Fire Marshal Division

August 10, 2020

**Re: JC Powder Coating
220 Progress Drive
Fuquay-Varina, NC 27526**

Application Number BCOM2007-0008

① LIFE SAFETY PLAN  
 3/16" = 1'-0"

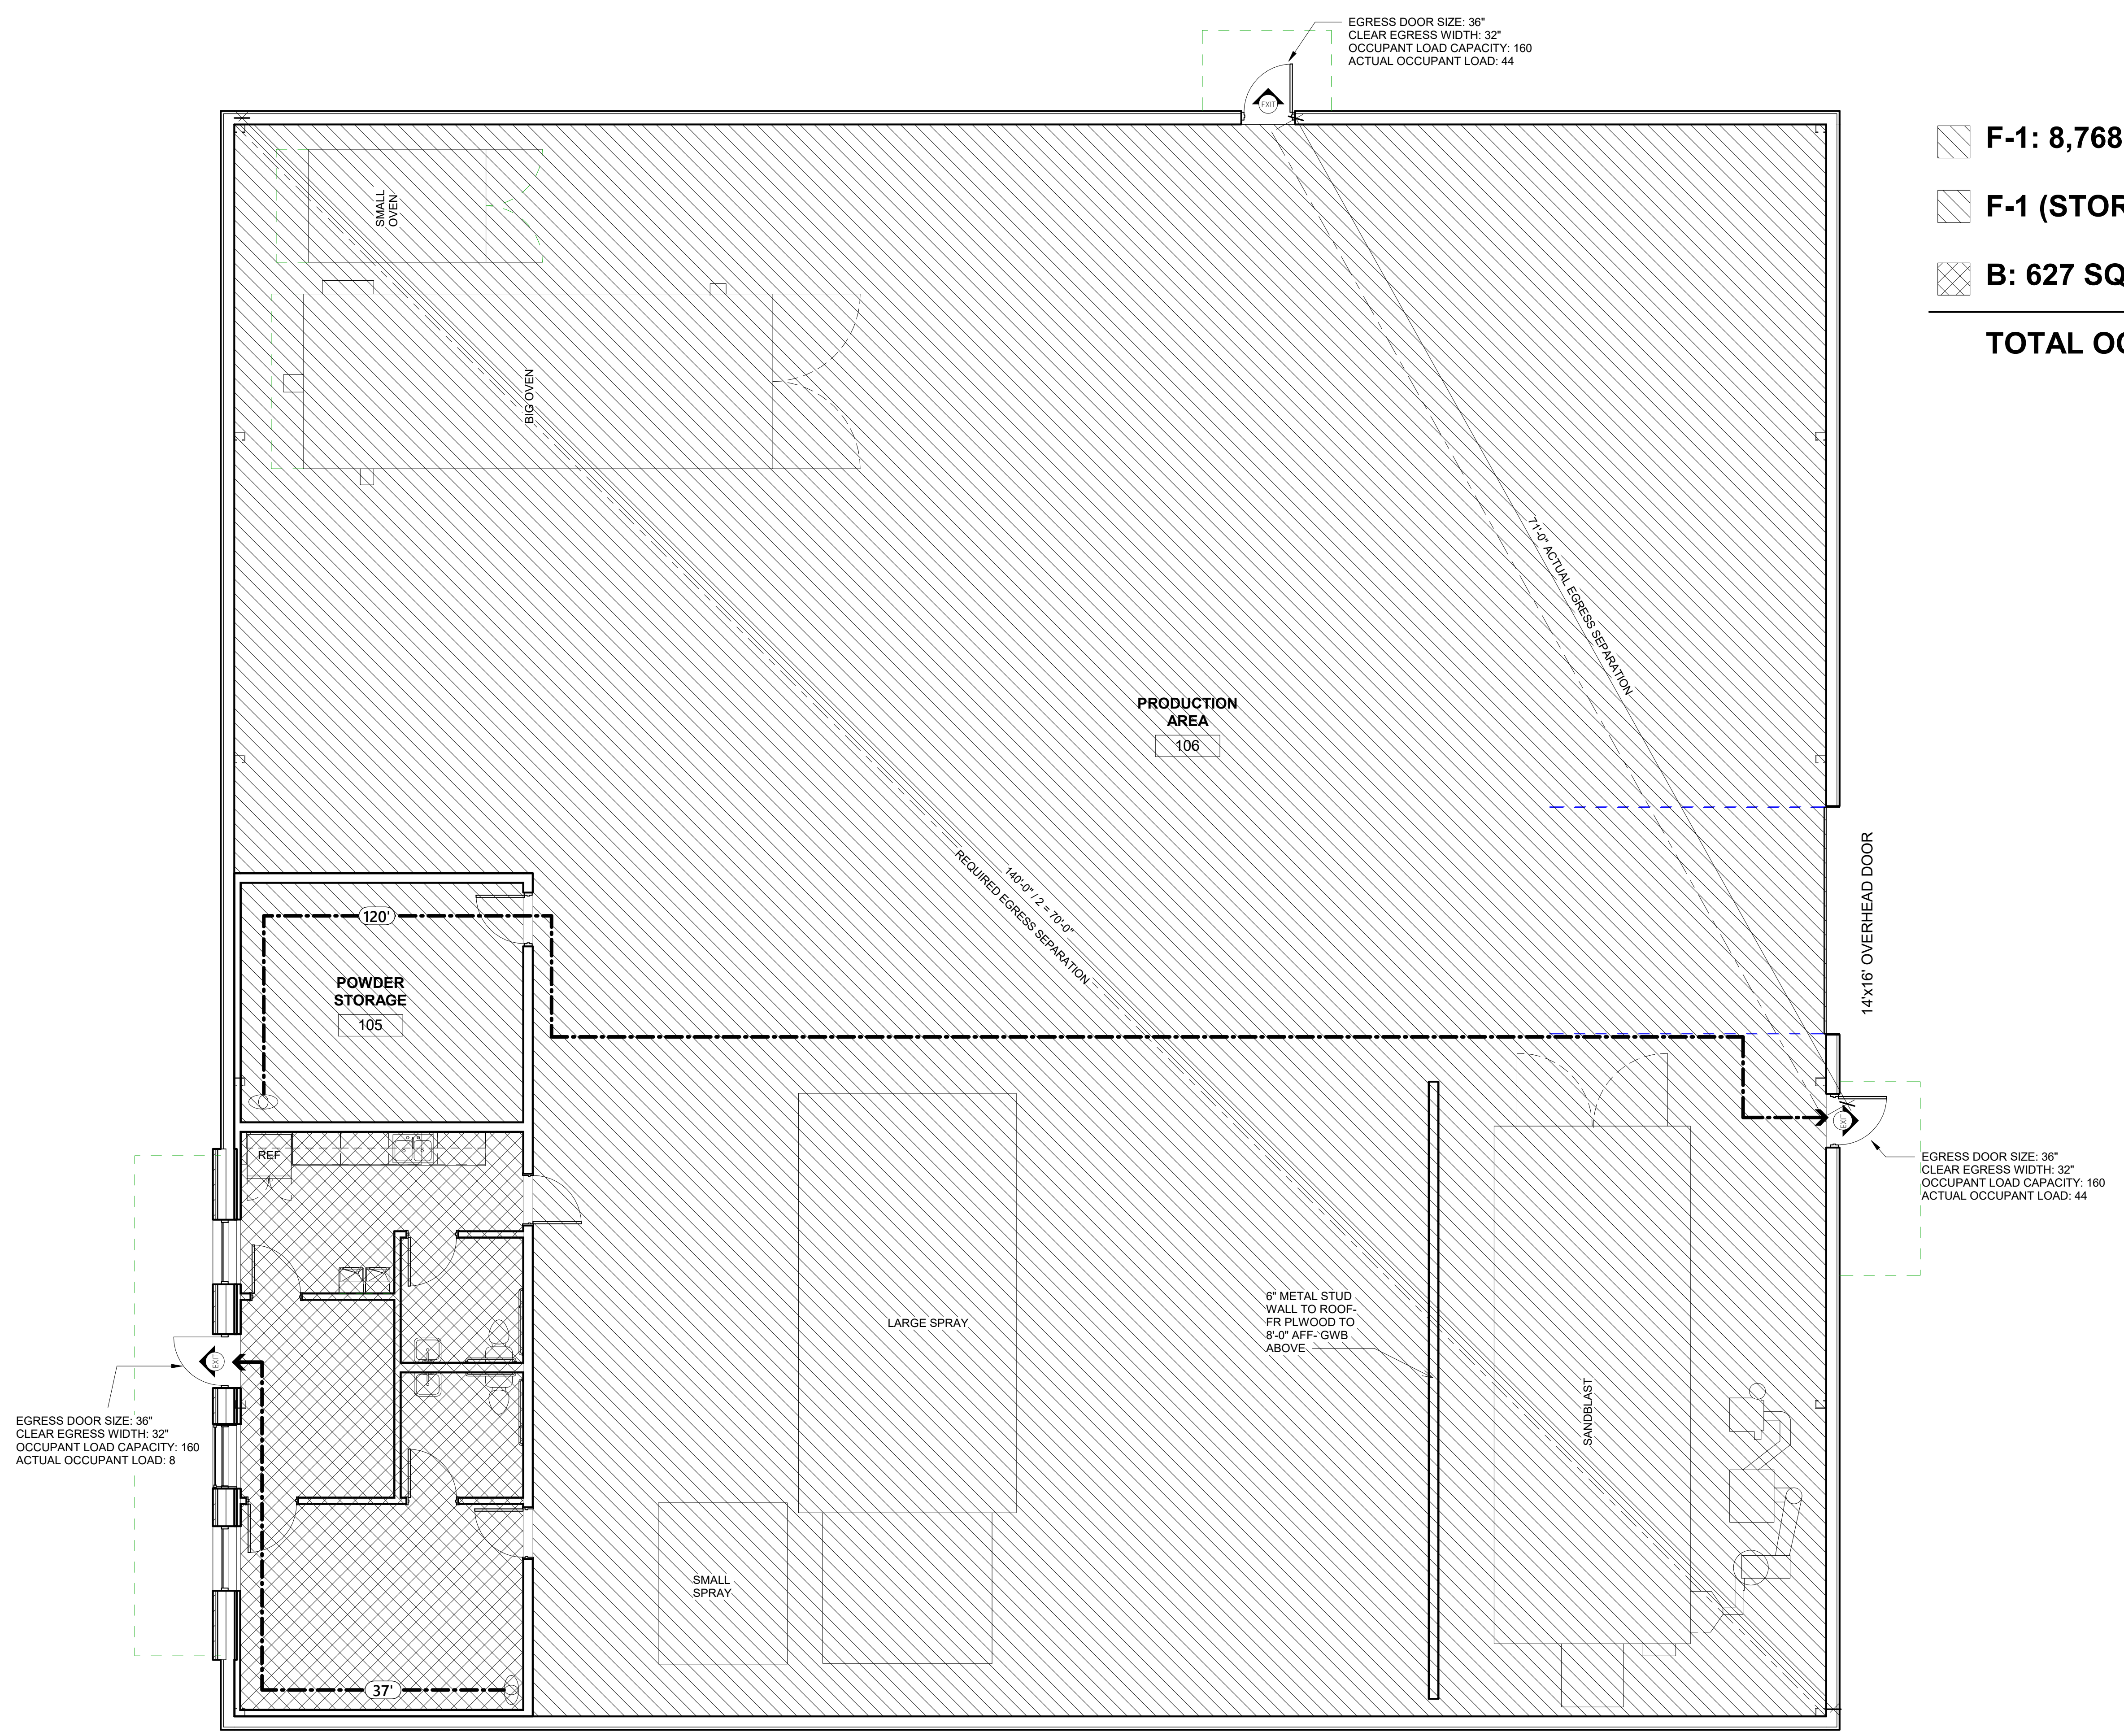
- **Fire Extinguisher**
 - Fire extinguishers of a rating no less than 4A:40 BC or two 2A:20BC shall be within a 30 ft. travel distance from the paint booths.

PAINT BOOTH DETAIL - NO SCALE | 1

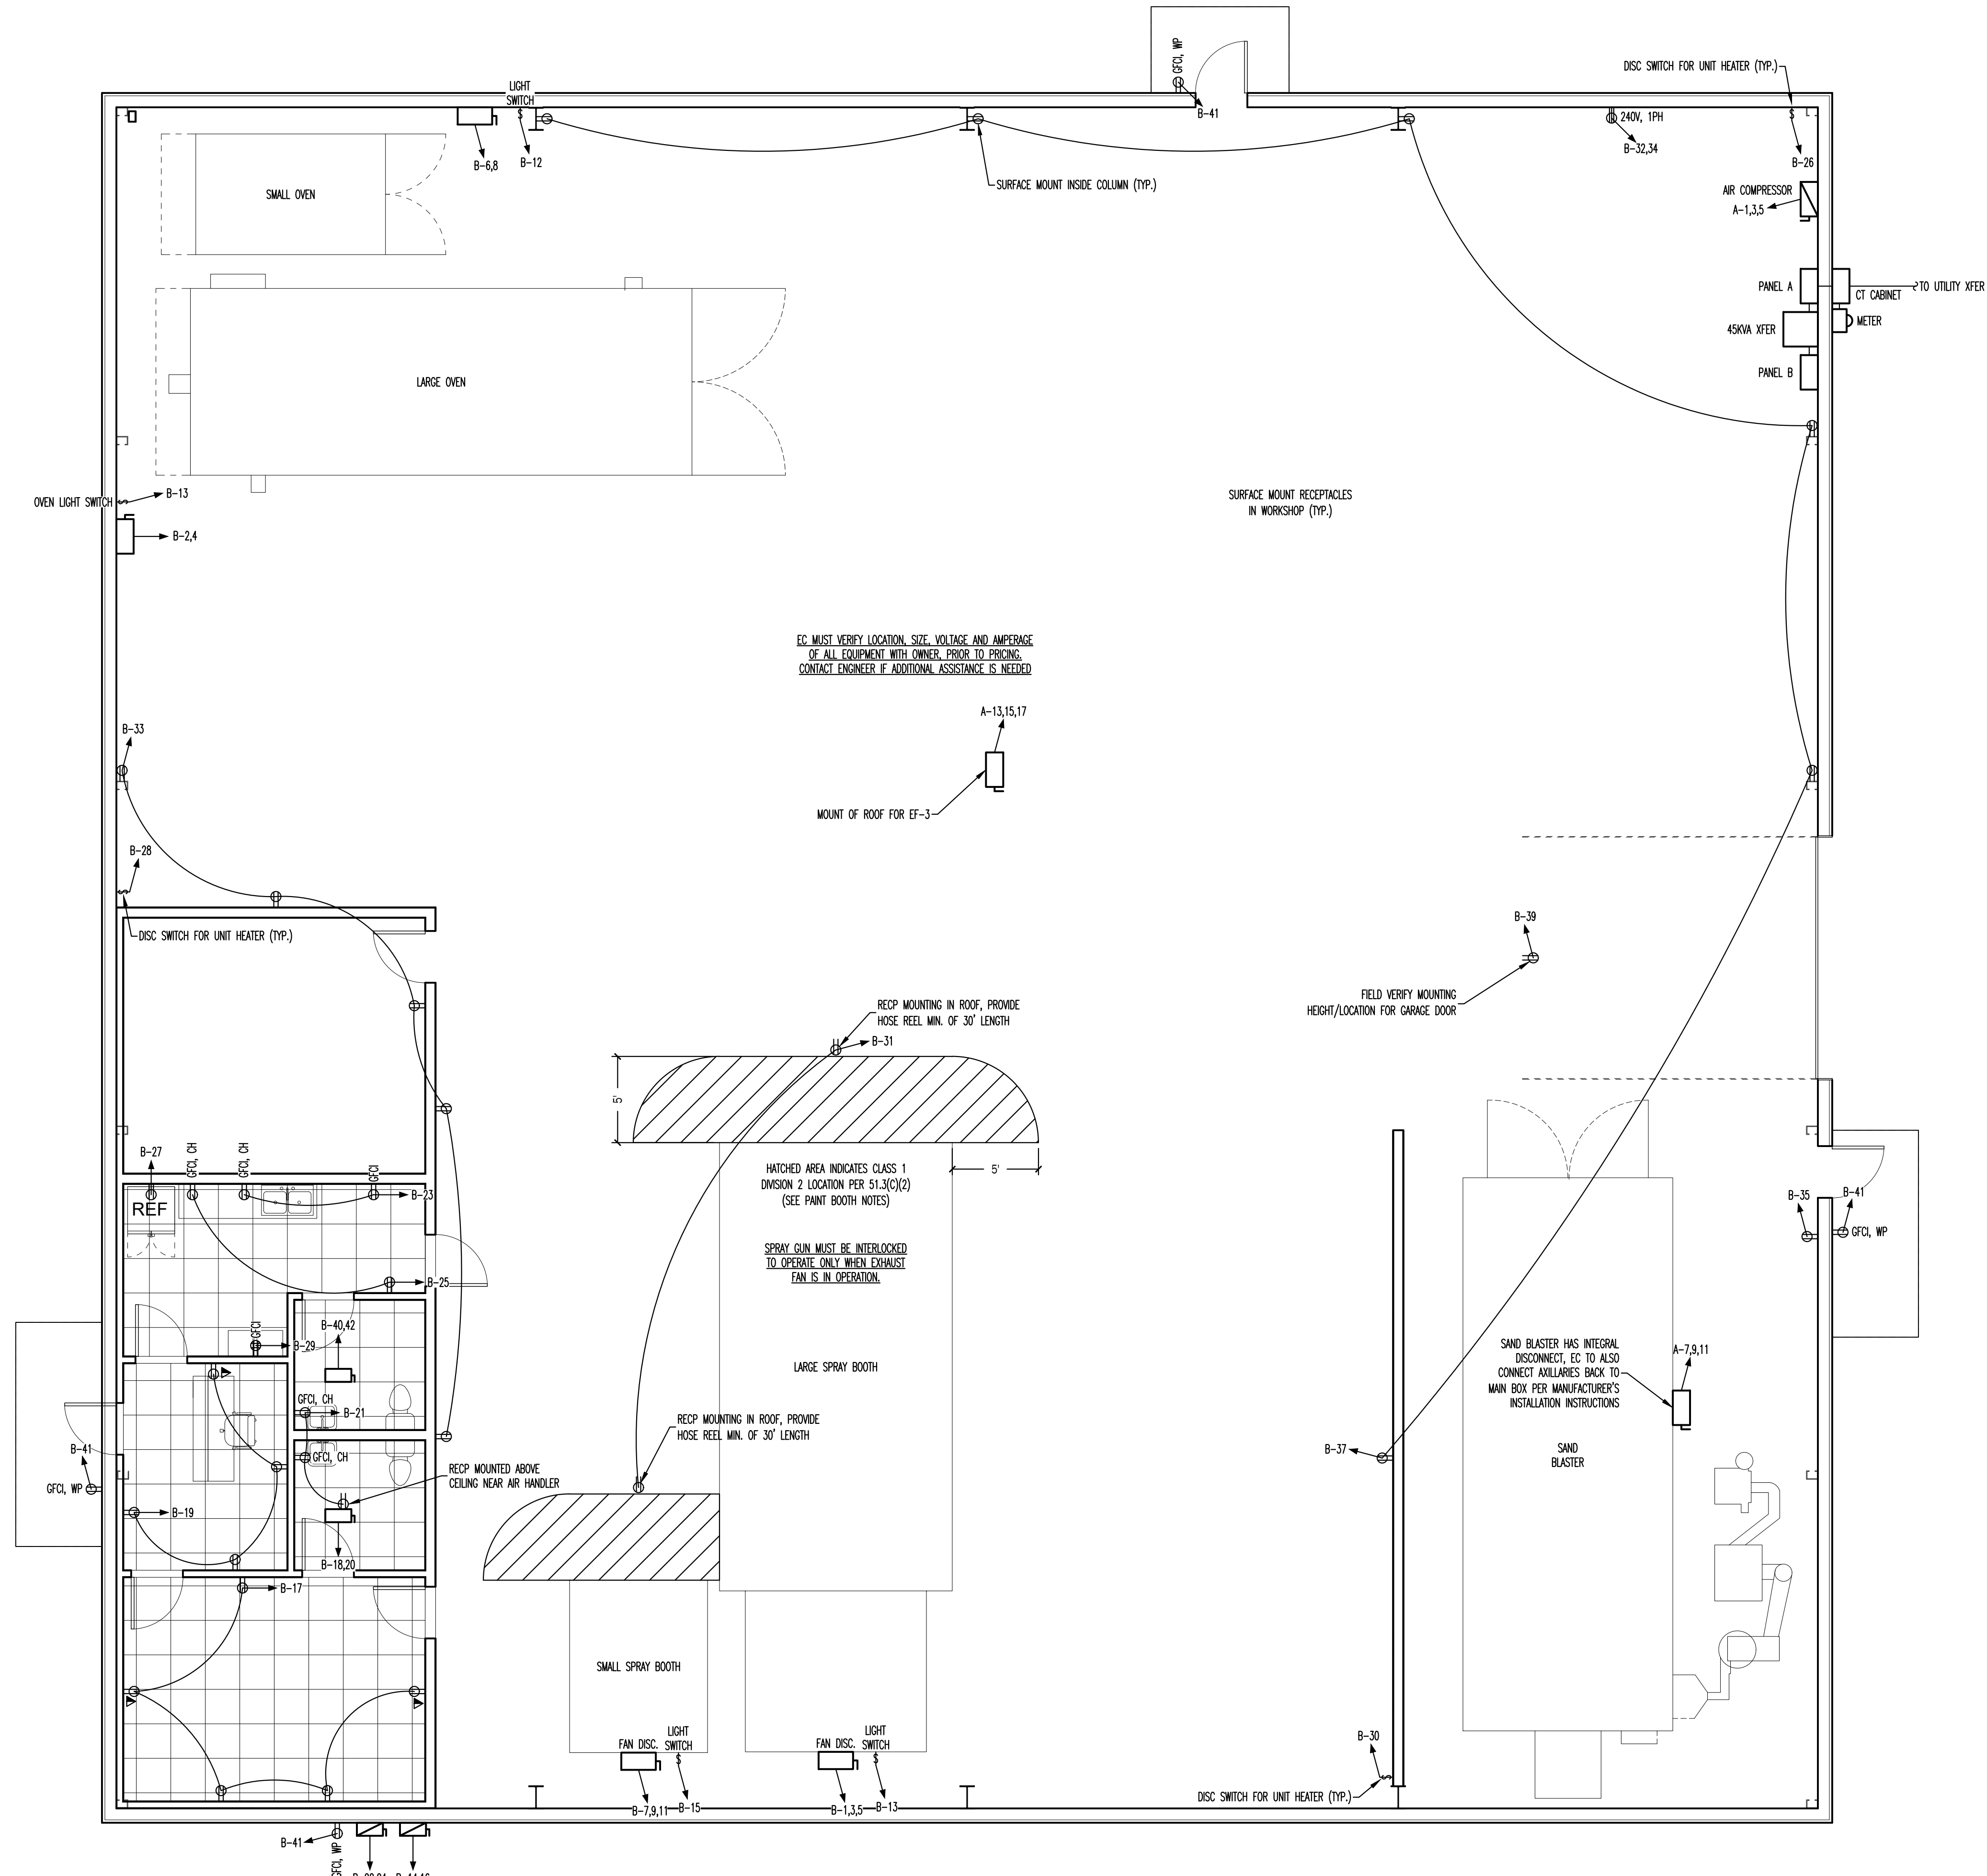
- **Dry-chemical systems.**
 - Dry-chemical extinguishing systems shall be installed, maintained, periodically inspected and tested in accordance with the North Carolina Fire Prevention Code, NFPA 17 and their listing.

- **Ventilation Interlocks**
 - With a total flooding system, the ventilation system for the paint booth is required to shut down before the system operates.
 - Spaying operations **CANNOT** be conducted without the operation of the ventilation system. An interlock must be provided between the ventilation system and spraying operation.
